OXFORDSHIRE COUNTY COUNCIL'S RESPONSE TO CONSULTATION ON THE FOLLOWING DEVELOPMENT PROPOSAL

Application no: 14/01888/F-3

Proposal: Erection of two local centre buildings - one to contain four apartments (3 x 2 bed and 1 x 1 bed) over one retail unit and a surgery and the other to contain four apartments (2 x 1 bed, 1 x 2 bed and 1 x 3 bed) over three retail units and a nursery

Transport

Title
Sketch Scheme:
 Ground and First Floor Plans

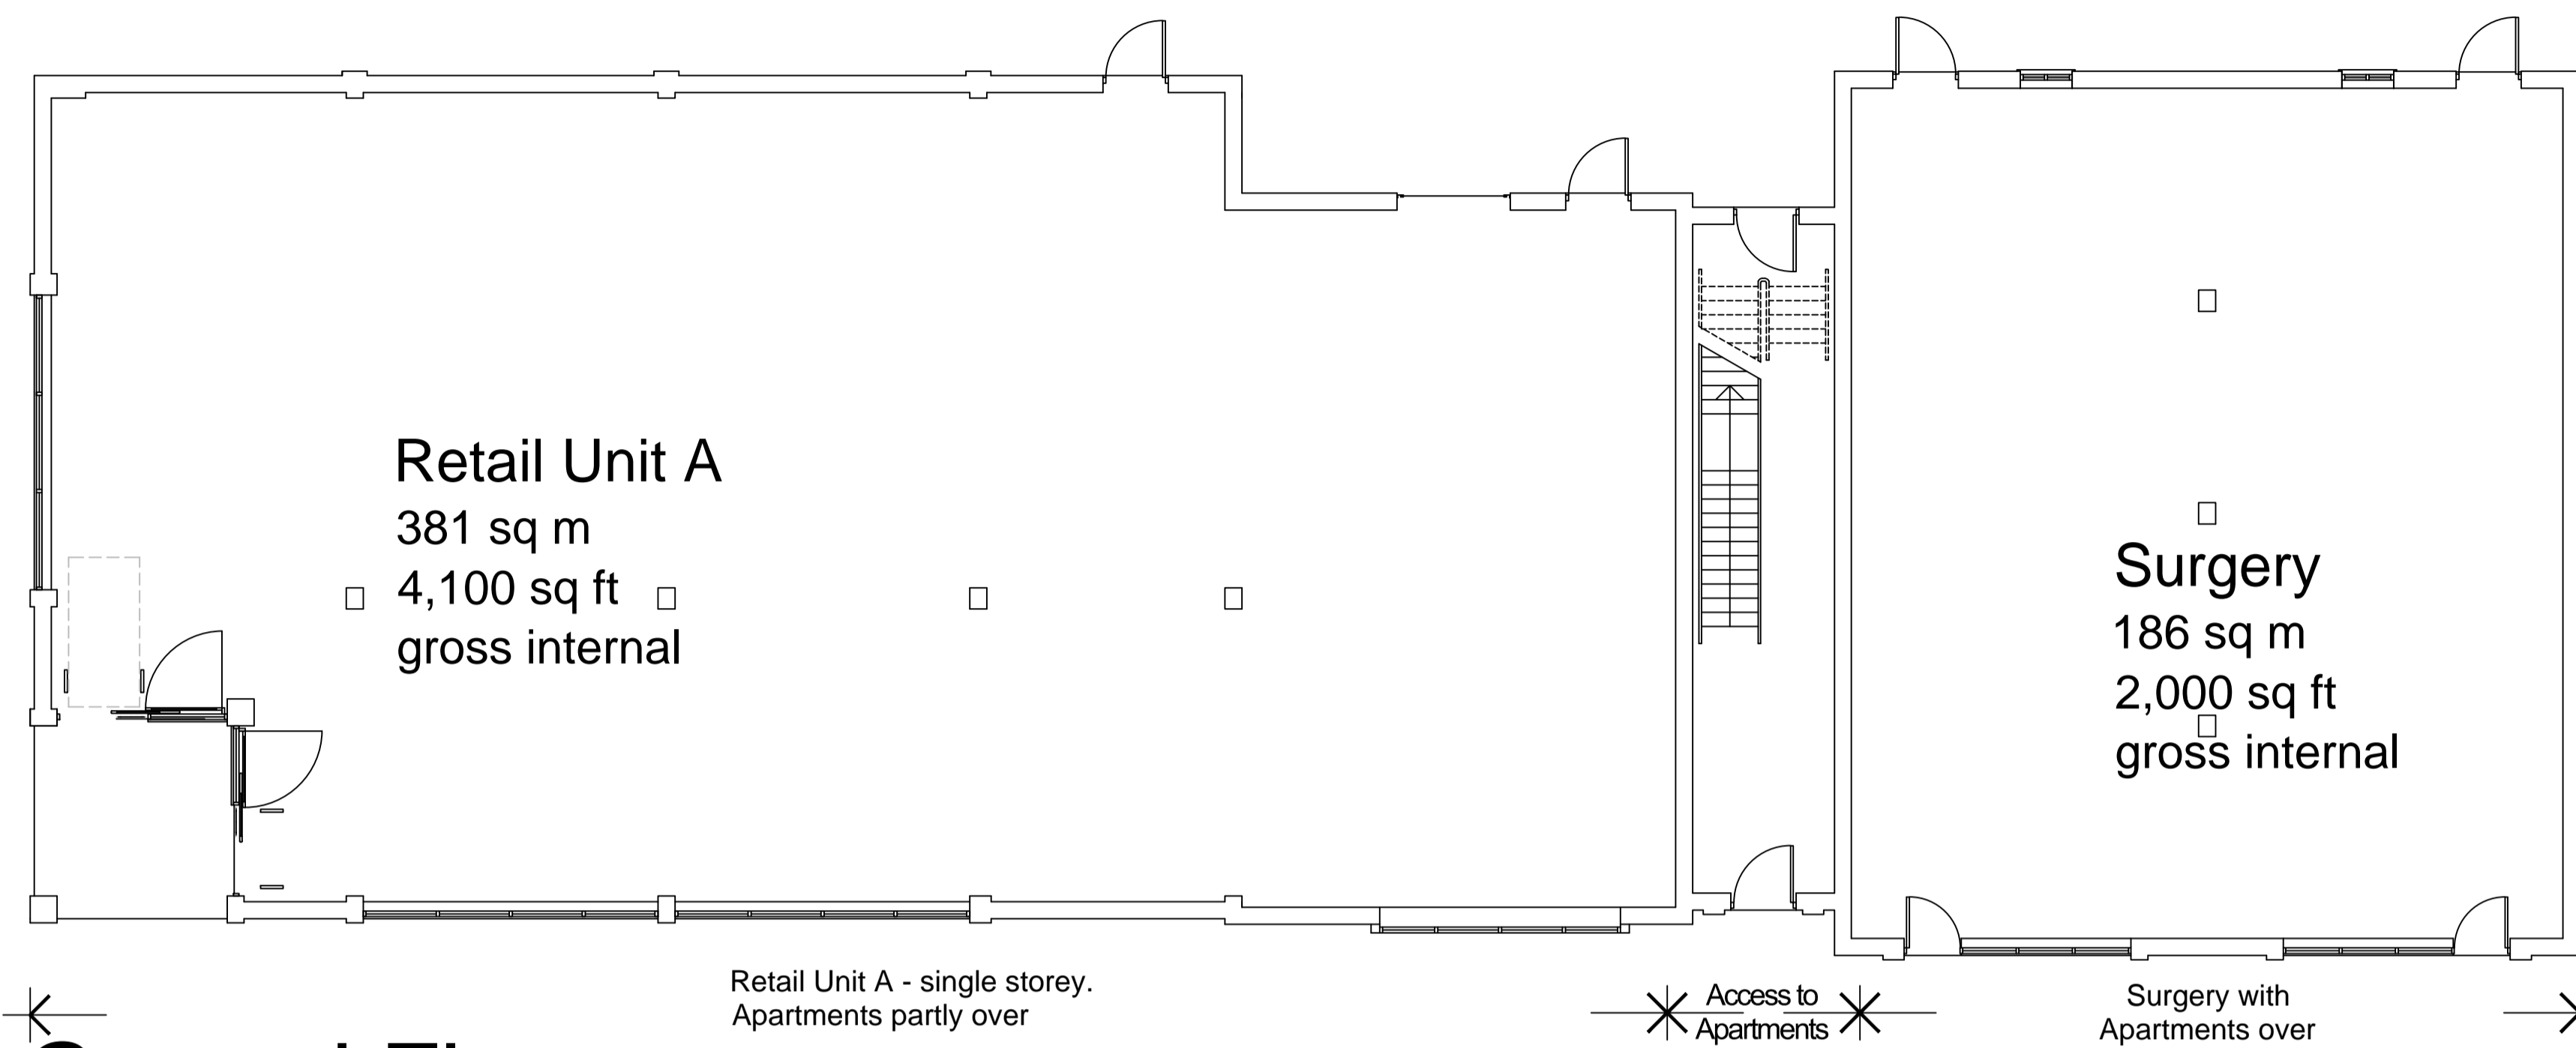
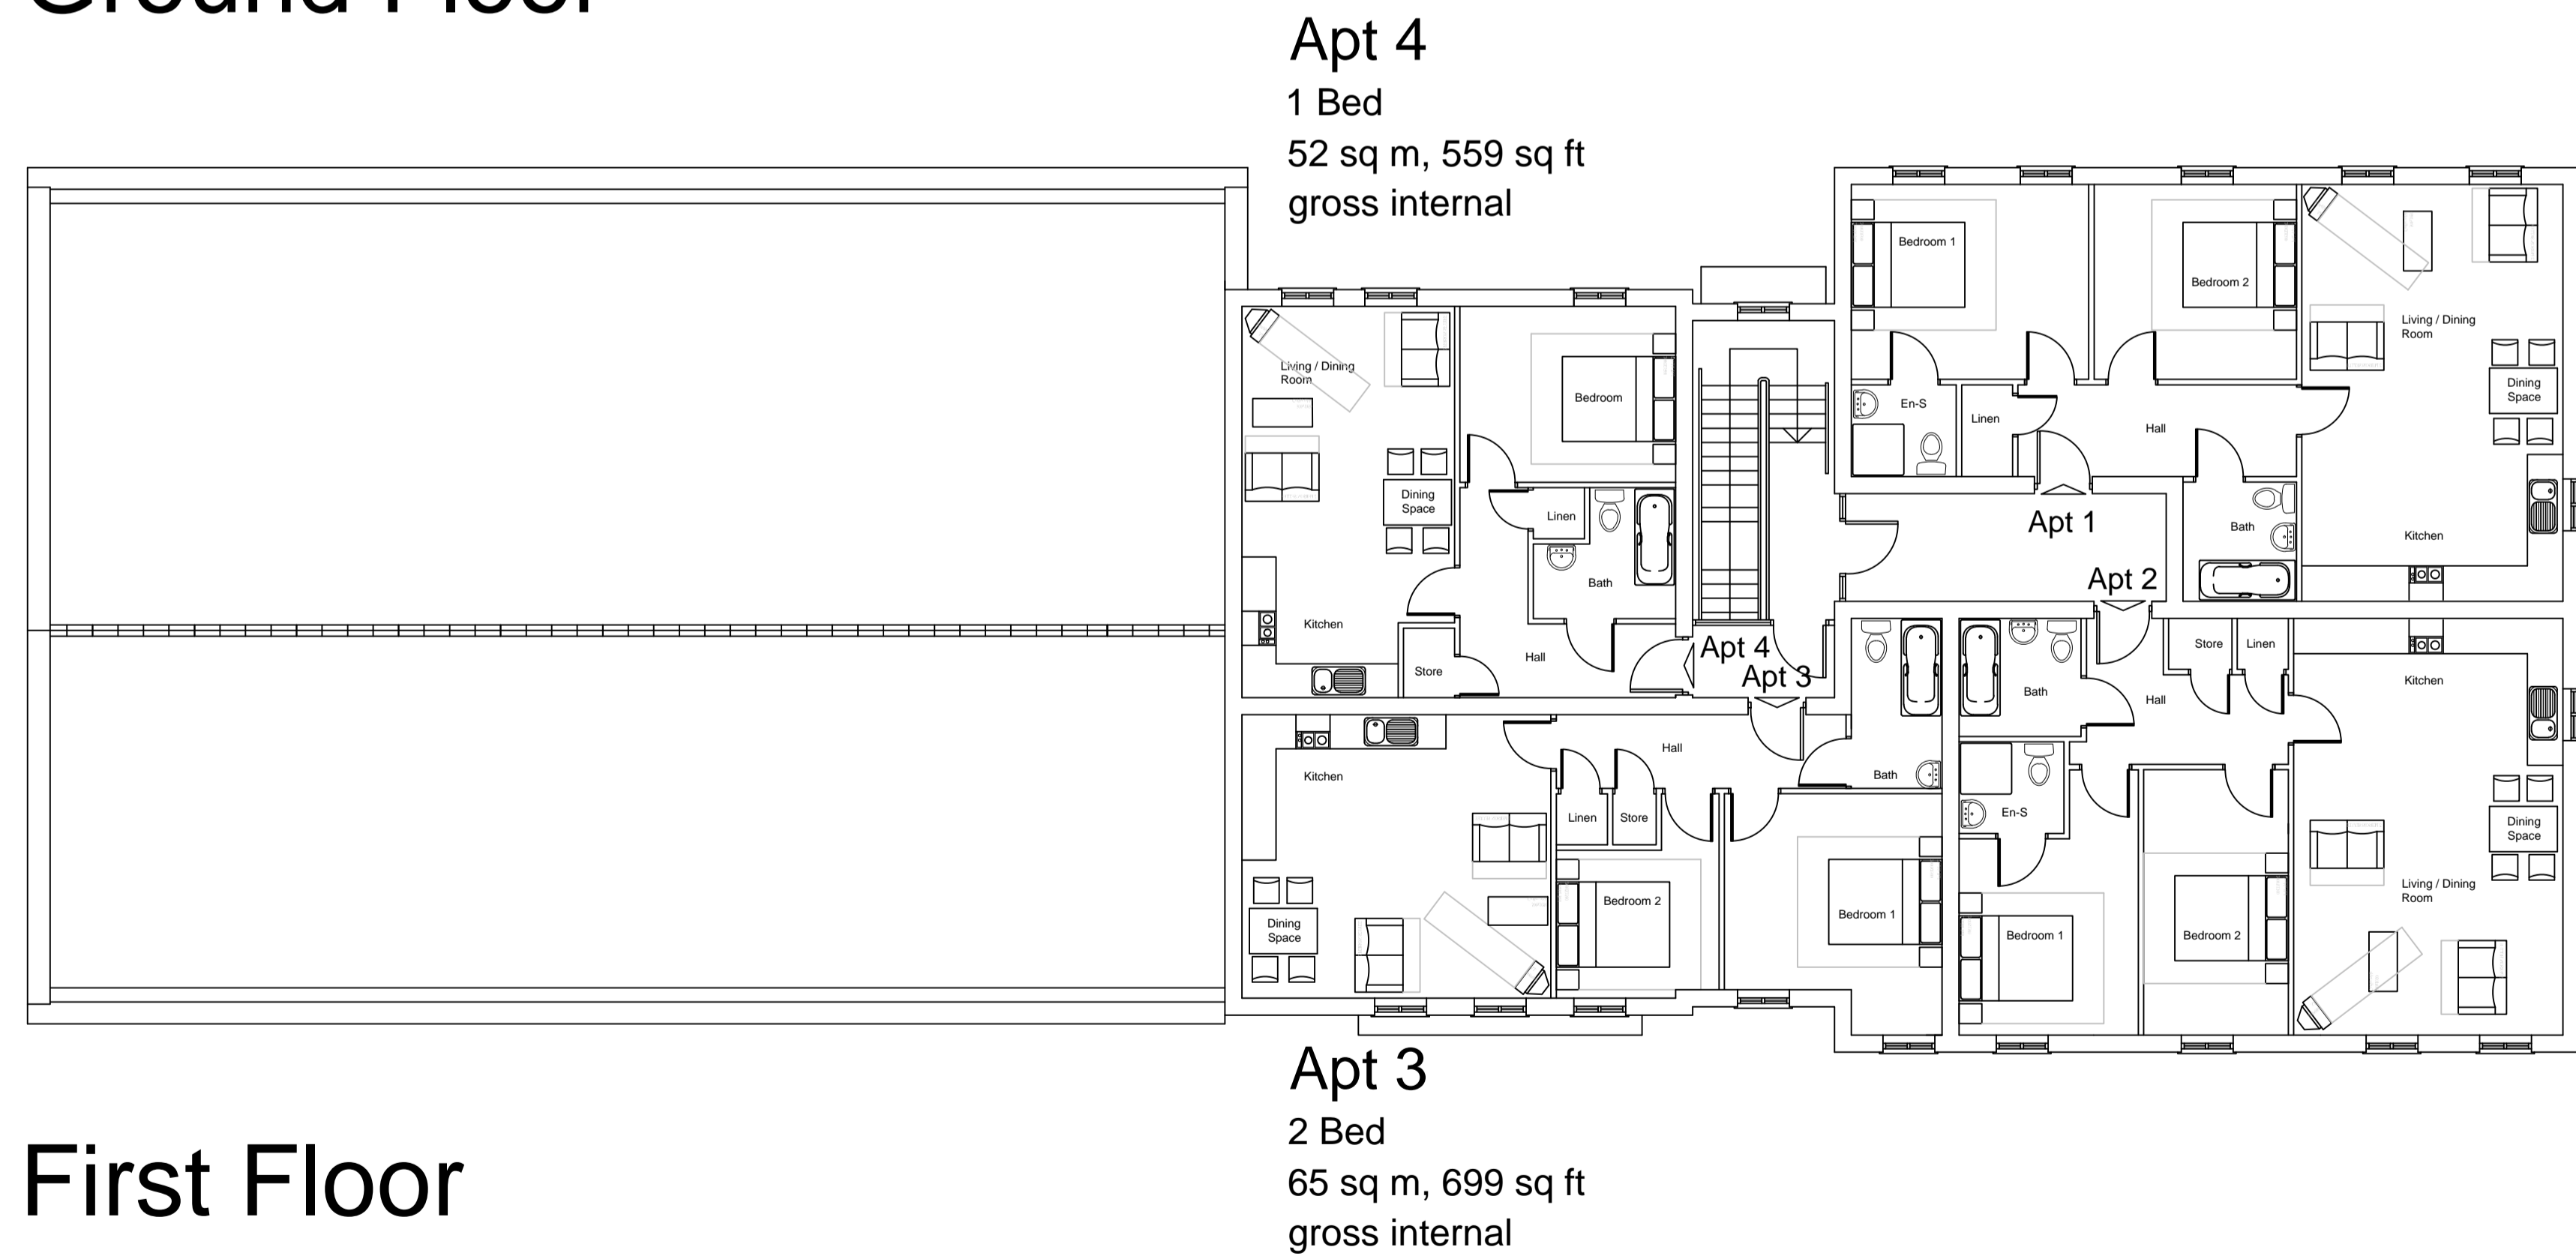
- The access to the service yard/car park for the surgery and convenience store, and residents' car park, is within a bus layby, and is gated. This could cause difficulties with buses being delayed getting into the layby, and people not able to exit because the layby is blocked by buses or unauthorised users – particularly important for healthcare workers at the surgery to be able to get in and out quickly. The access should be moved.

- I am concerned that the correct kerblines with the service bay outside the convenience store is still not shown. Also, I requested in my previous response confirmation of the route taken by deliveries from this bay into the store, which has not been provided.
